Hunter Water Corporation
ABN 46 228 513 446

HW Ref: HW2017-1215/18/4

RE: RESPONSE TO ENVIRONMENTAL IMPACT STATEMENT - JOHN HUNTER HEALTH AND INNOVATION PRECINCT (SSD-9351535)

Attached: Preliminary Servicing Advice - John Hunter Health and Innovation Precinct,
10 June 2020 (2019-942)

Figure 2-3: Existing Hunter Water Corporation water main surrounding the site (Based on surveys and DBYD)

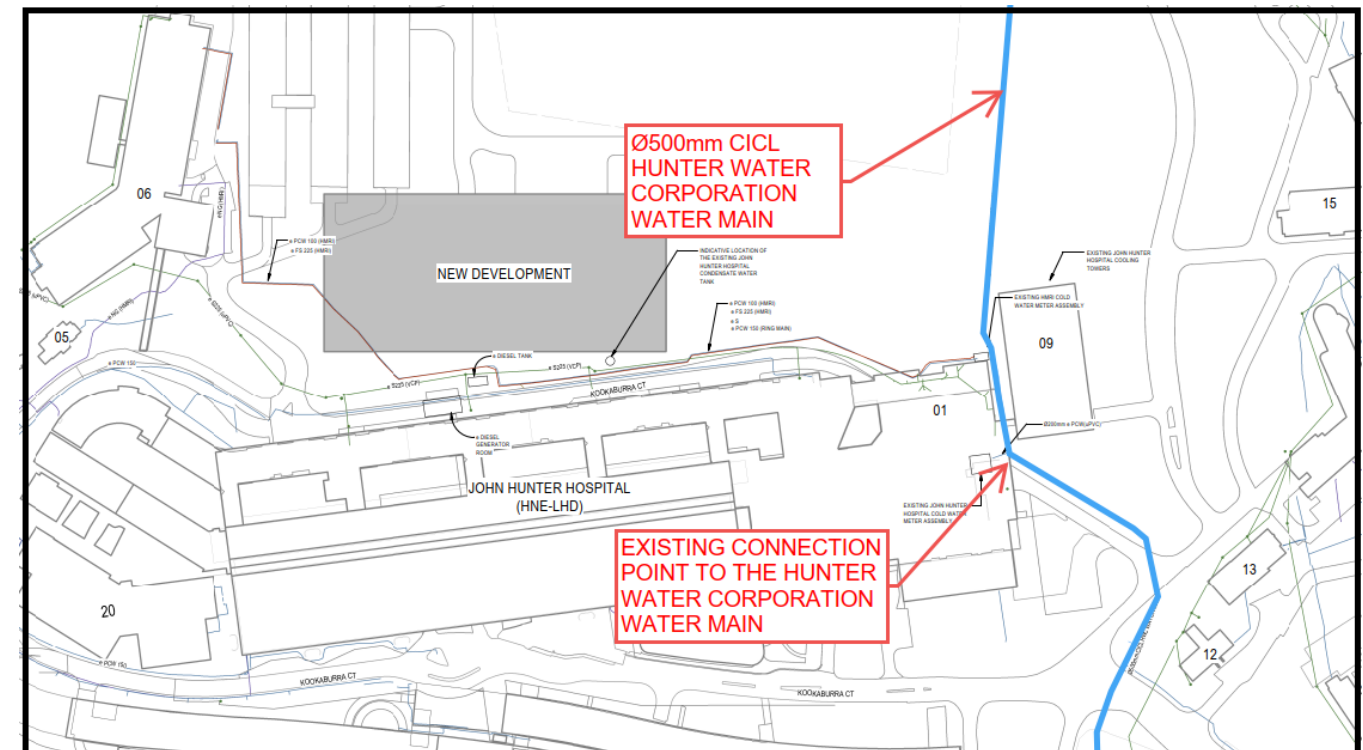
- The site is traversed by a 500mm Cast Iron Cement Lined (CICL) watermain that is protected by an Easement for Water Supply (variable width) in favour of Hunter Water. Plans submitted as part of the Preliminary Servicing Advice application propose a new access road over and directly adjacent to this watermain. The proposed road works must comply with Hunter Water's Building Over or Encroaching on Hunter Water Easements or Property Policy.

In respect to the Hydraulic and Fire Services SSDA Utility Report prepared by Warren Smith Consulting Engineers, Hunter Water requires that future analysis, design and documentation references relevant Hunter Water standards and guidelines rather than Sydney Water's.
